HOMESTEAD NORTH AT STERLING RANCH

EARLY GRADING AND EROSION CONTROL PLANS

JUNE 2021

PCD-ENGINEERING REVIEW COMMENTS
IN BLUE BOXES WITH BLUE TEXT

SHEET 1 OF 10
JOB NO. 25188.00

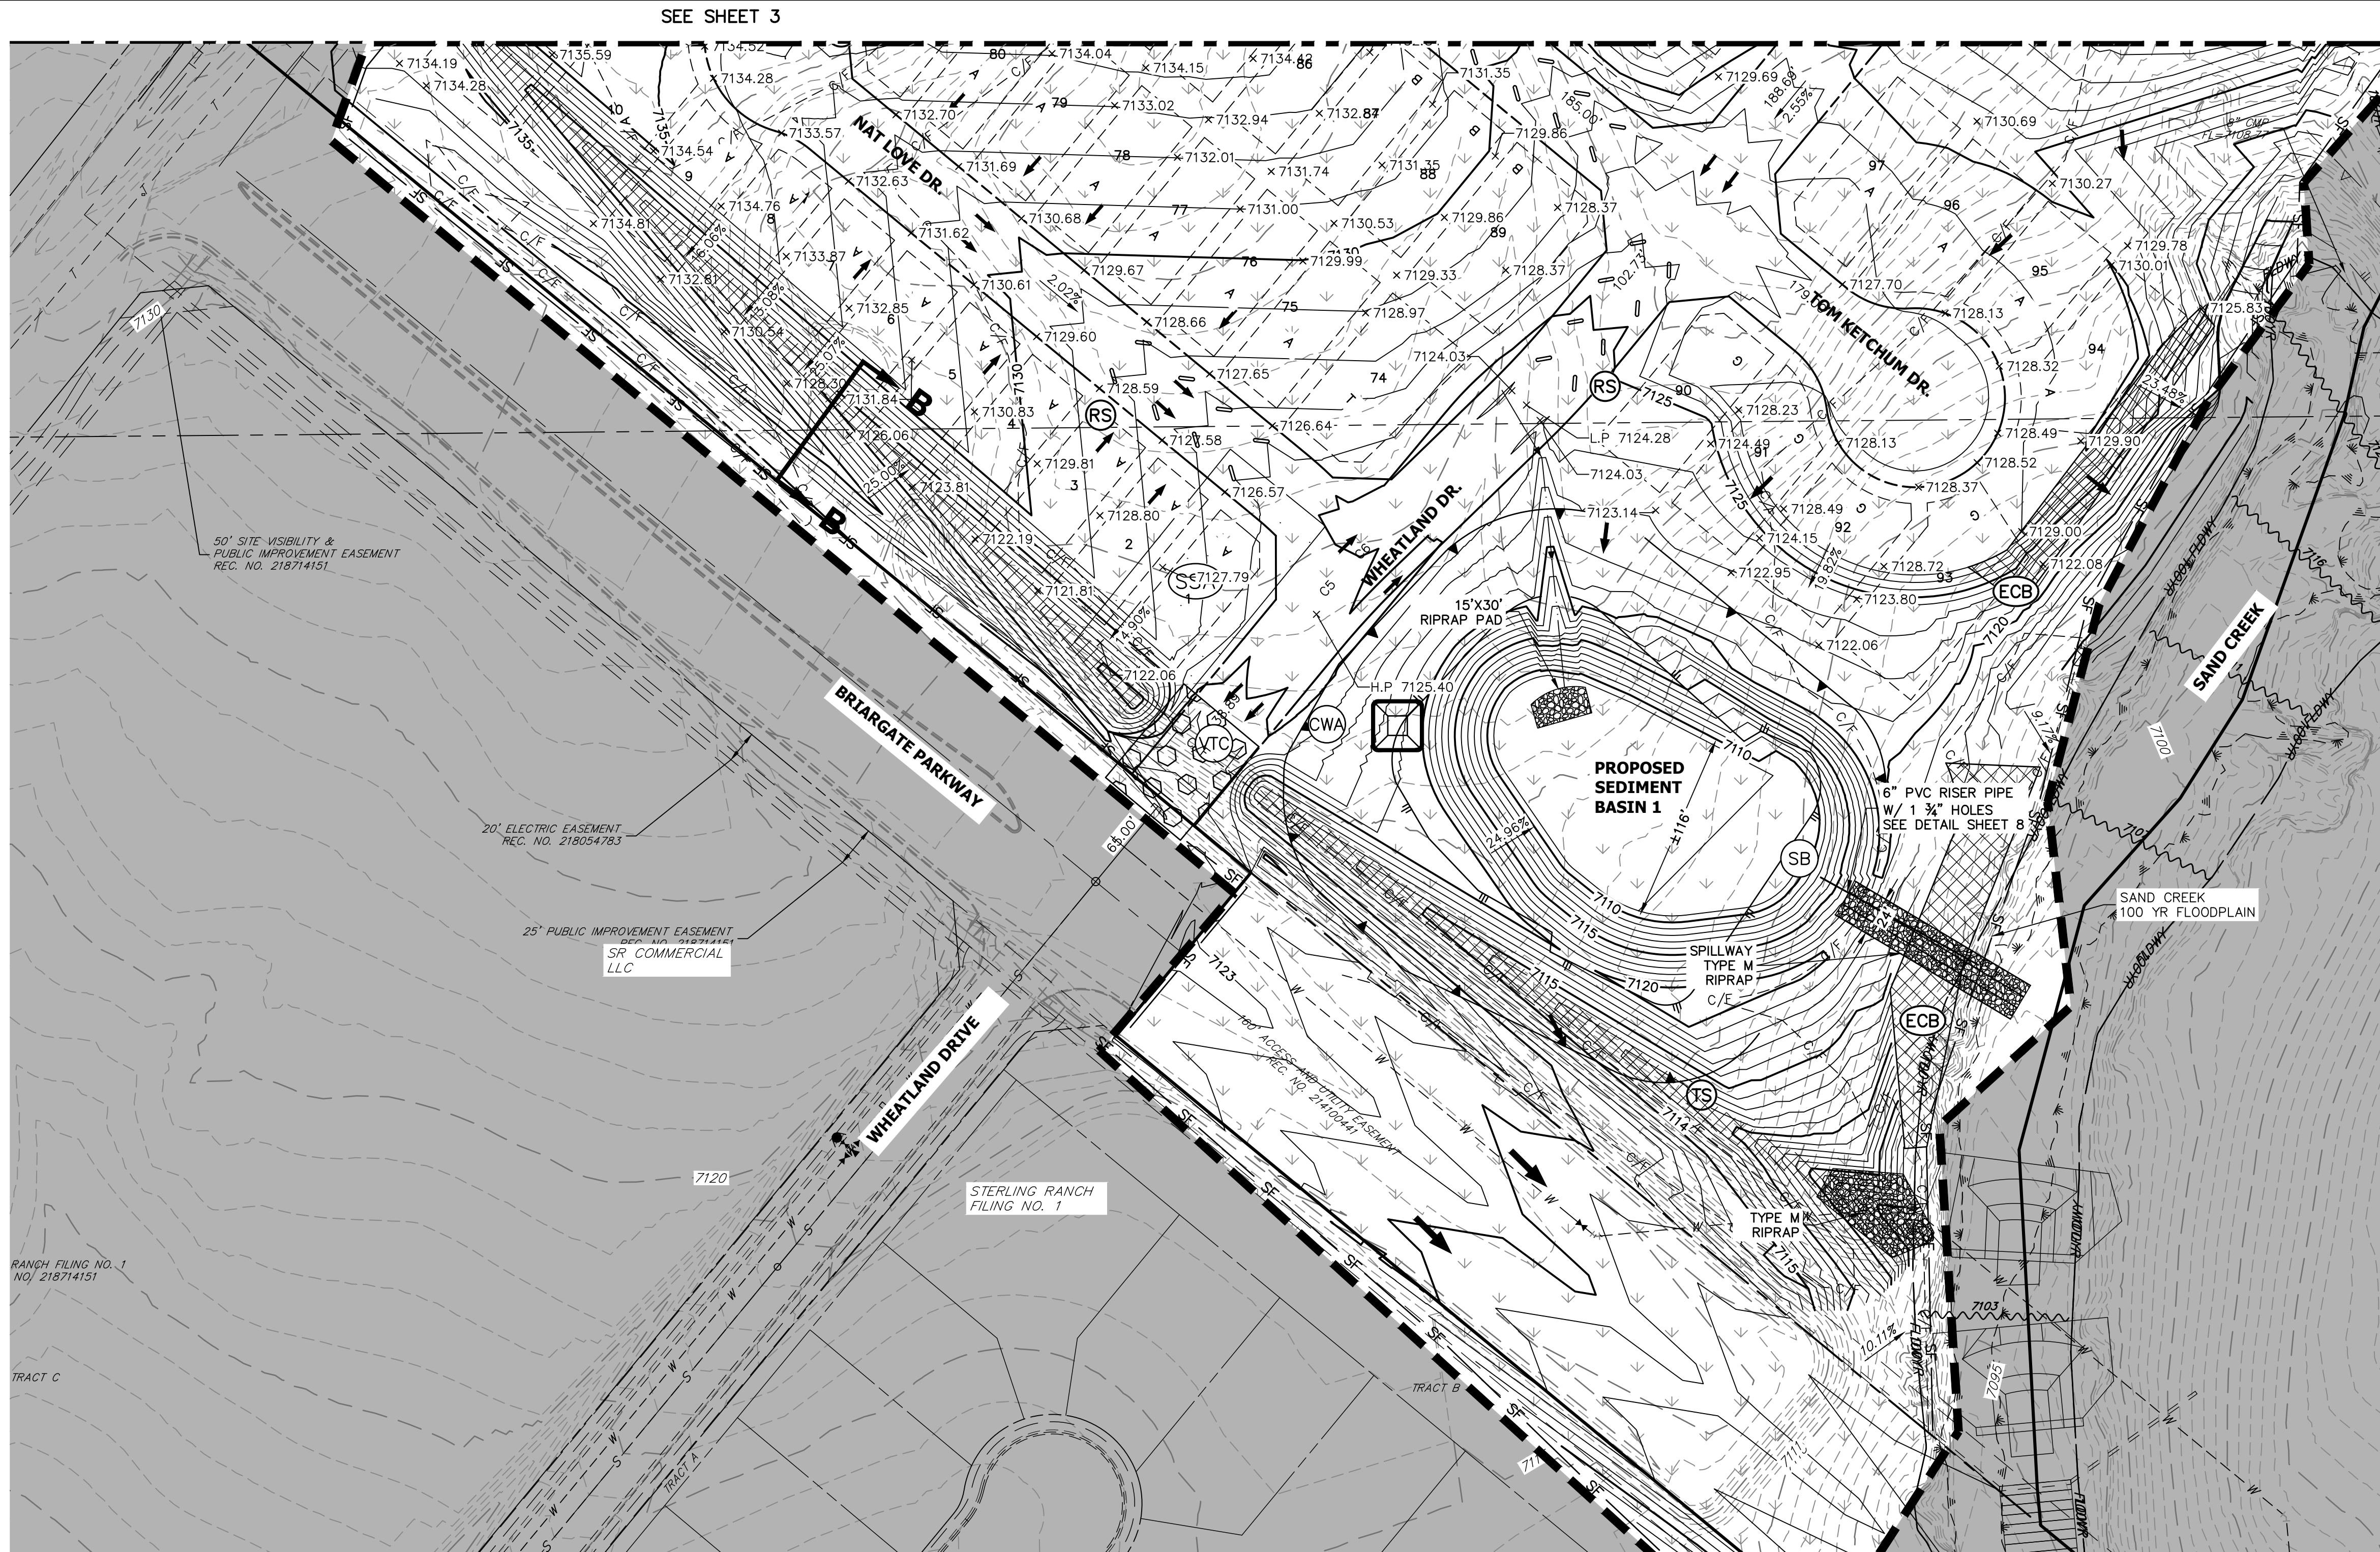
Provide cross-sections for all swales and spillways.

SHEET 3 OF 10
JOB NO. 25188.00

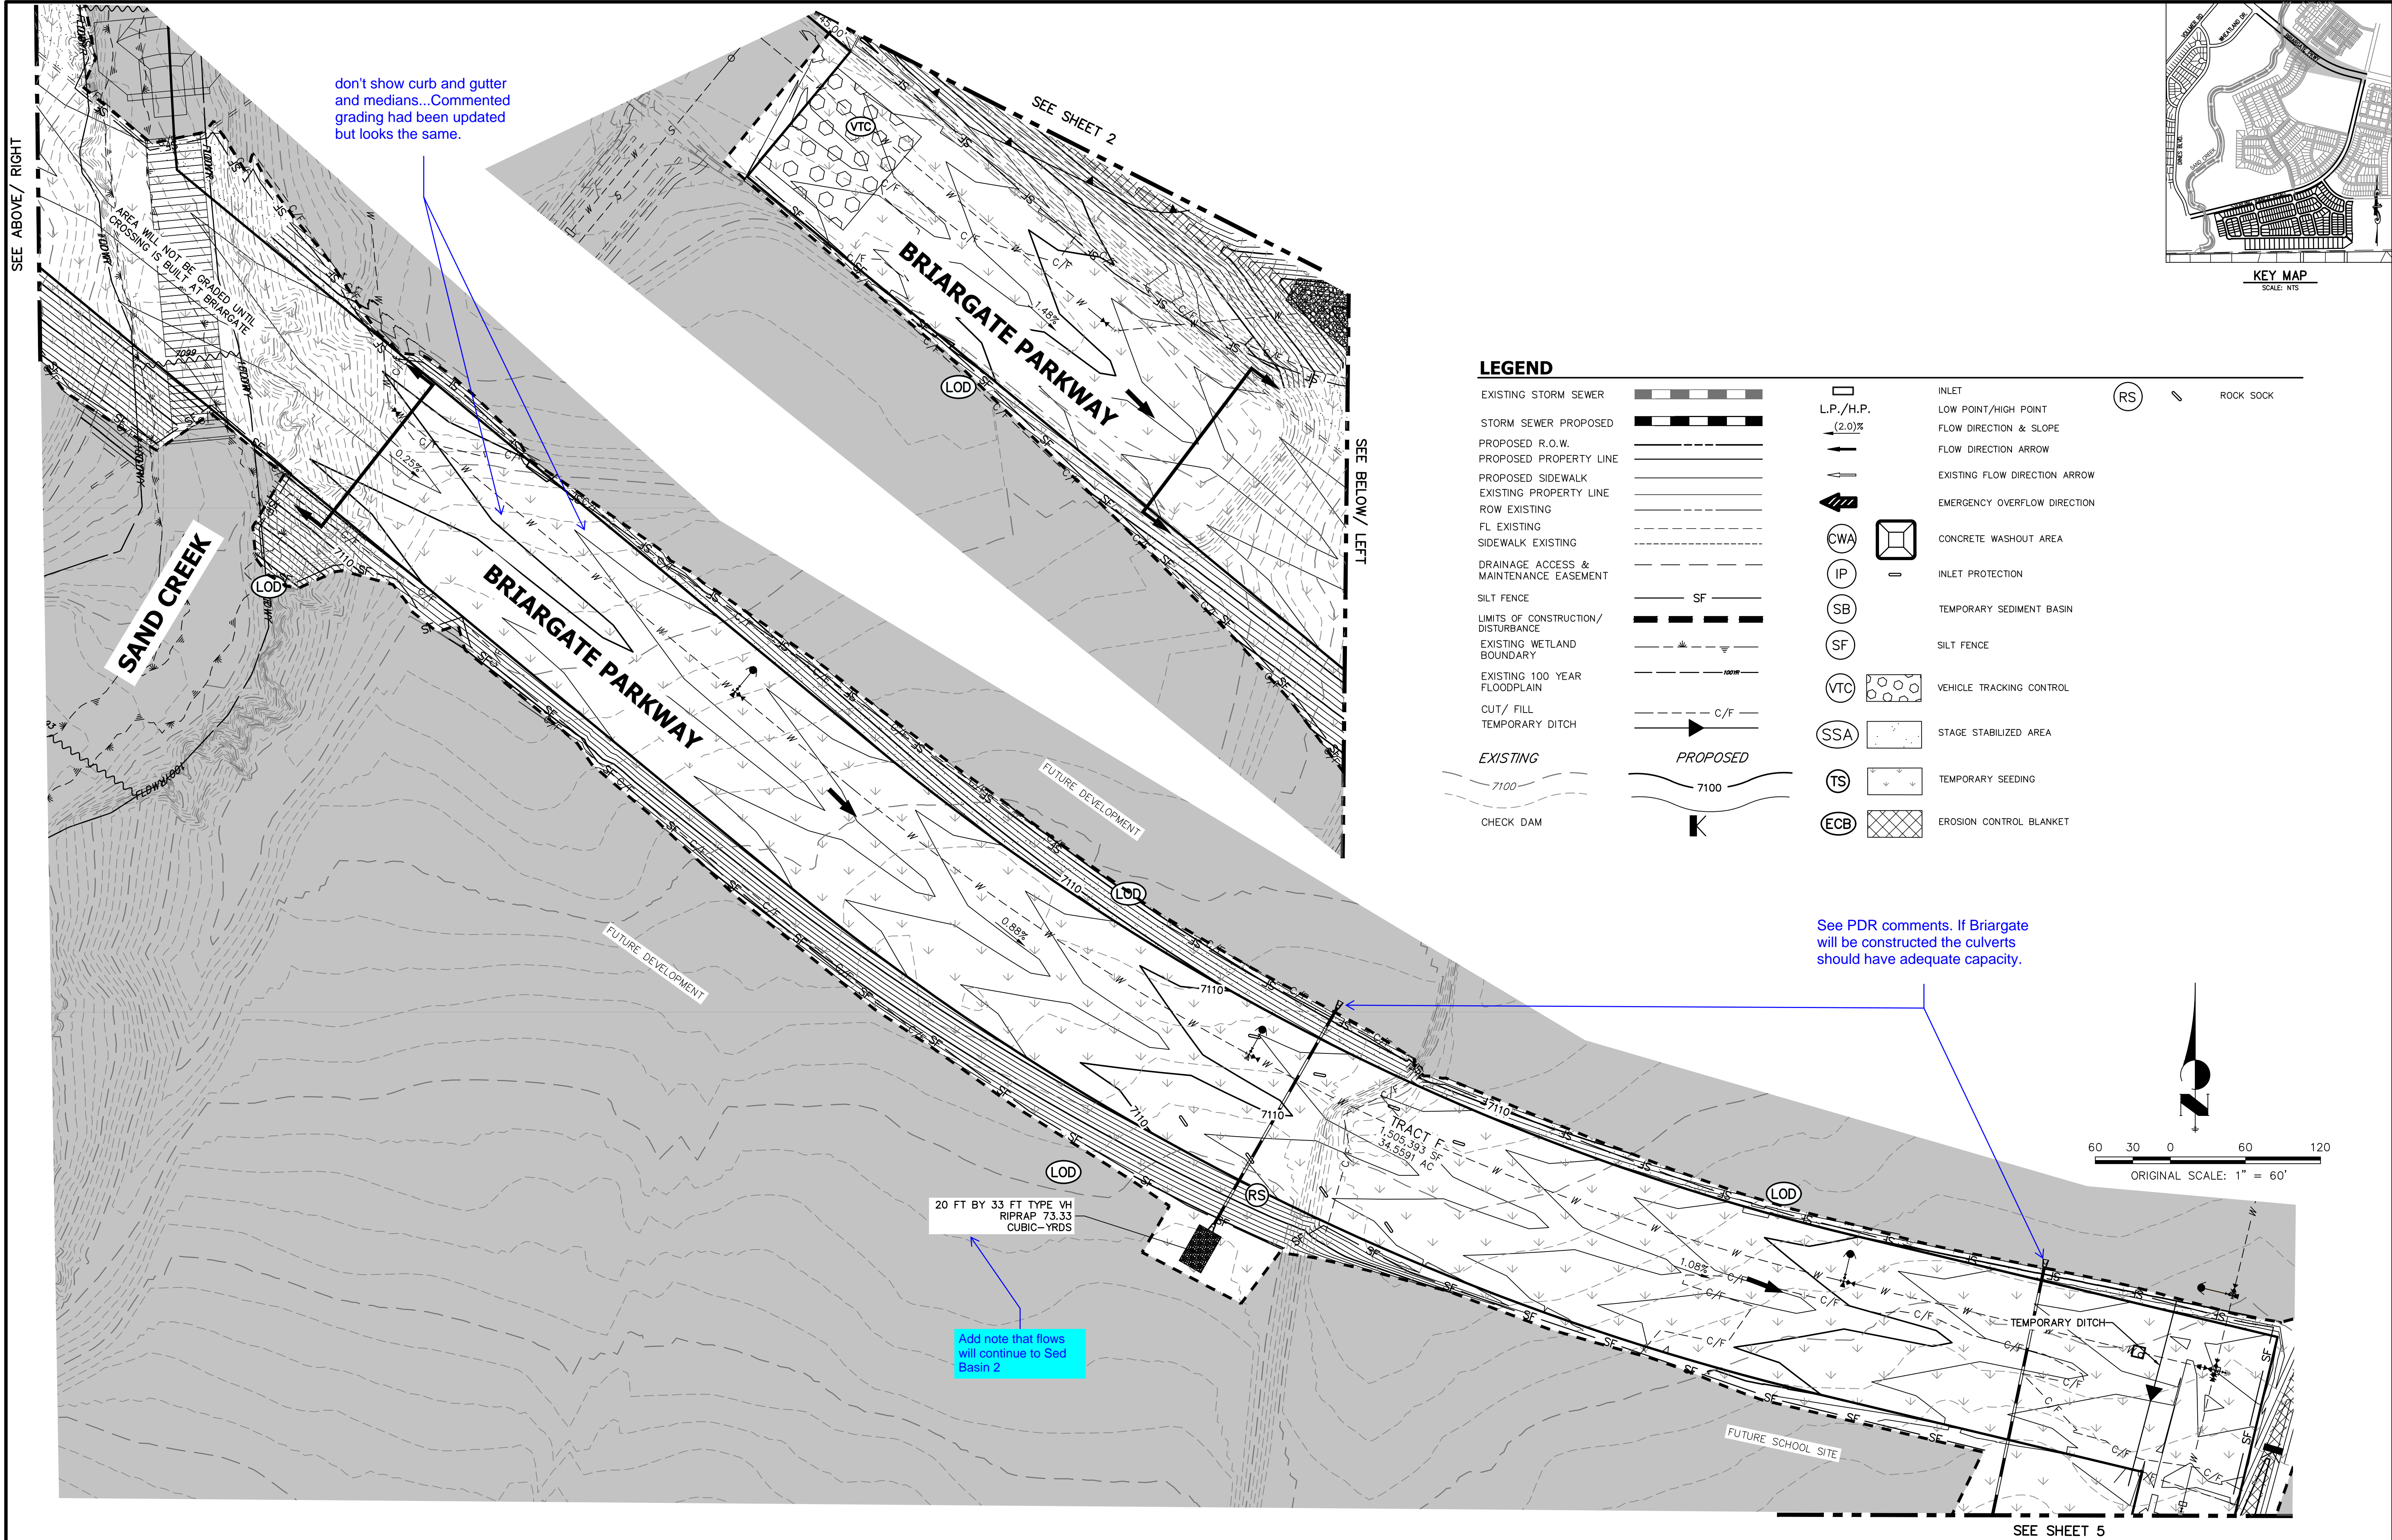
don't show curb and gutter and medians...

There should be ditch-outs and sediment basins where flows can exit the road platform.

much lower than FAE value
